PORTLAND MAINE

November 3, 2010

62 East Commonwealth – 298 B013 – R-3 – unpermitted deck

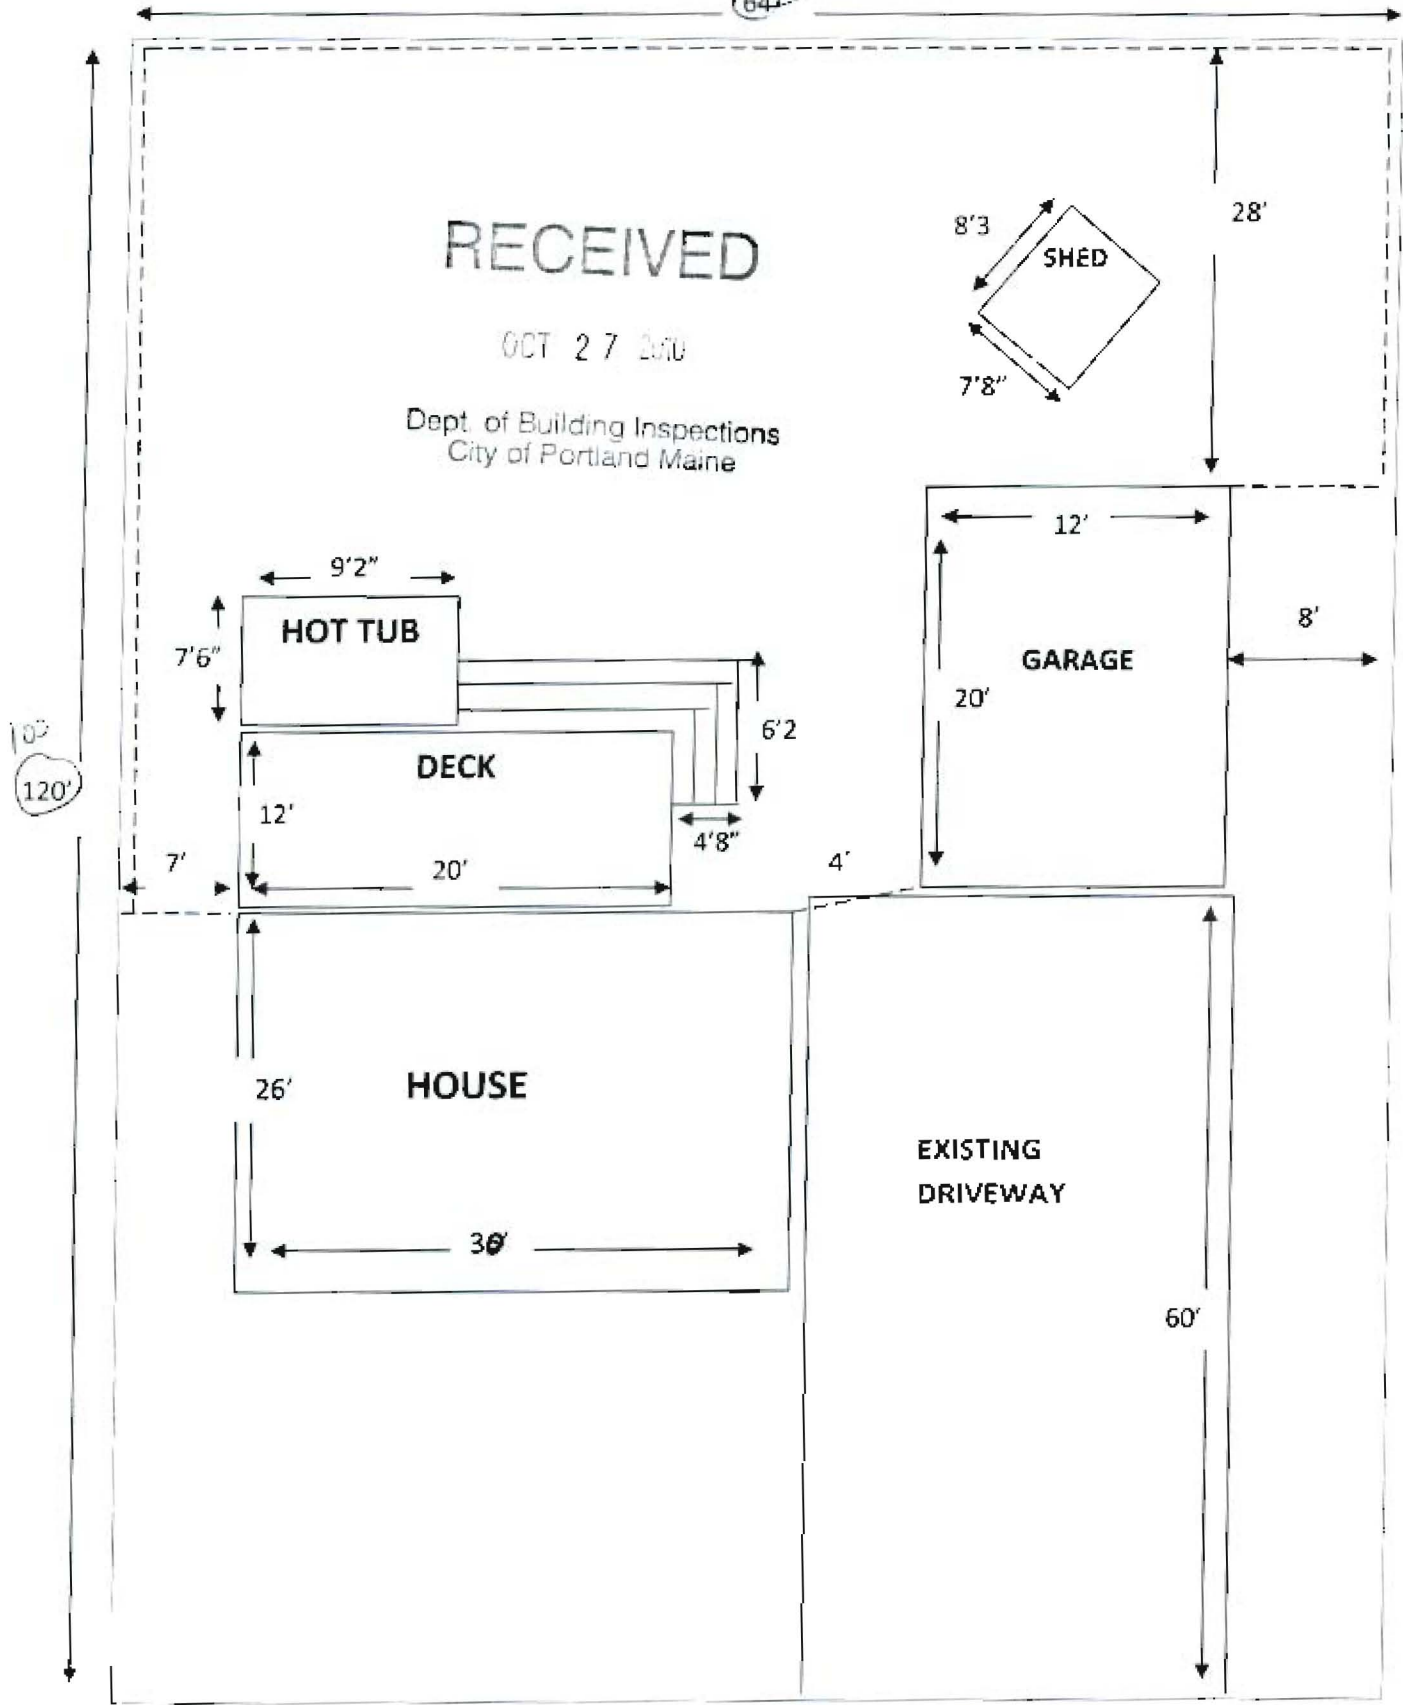
In your reviewing your permit application (#10-1350) to install a spa pad and hot tub, I discovered that the deck on the rear of the house shown on the plot plan was not permitted. You need to apply for a building permit for the deck to bring your property into compliance. The building permit application must have an accurate plot plan and all the details of how the deck has been built as if it was being built now.

Your property is located in the R-3 residential zone. The required rear yard setback is twenty-five (25) feet and the required side yard setback is eight (8) feet. The plot plan that you submitted with the application for the spa pad and hot tub was not accurate. According to the assessors, your lot is sixty (60) feet wide by one hundred (100) feet deep. Your plot plan gave the dimensions as 64' by 120'. The front property line starts at the edge of the right of the way and not at the street. Also on the plot plan the dimensions of the house were given as 26' x 36'. The house is 26' x 30'.

You have thirty days to bring your property into compliance by applying for the building permit. I have included a building permit application.
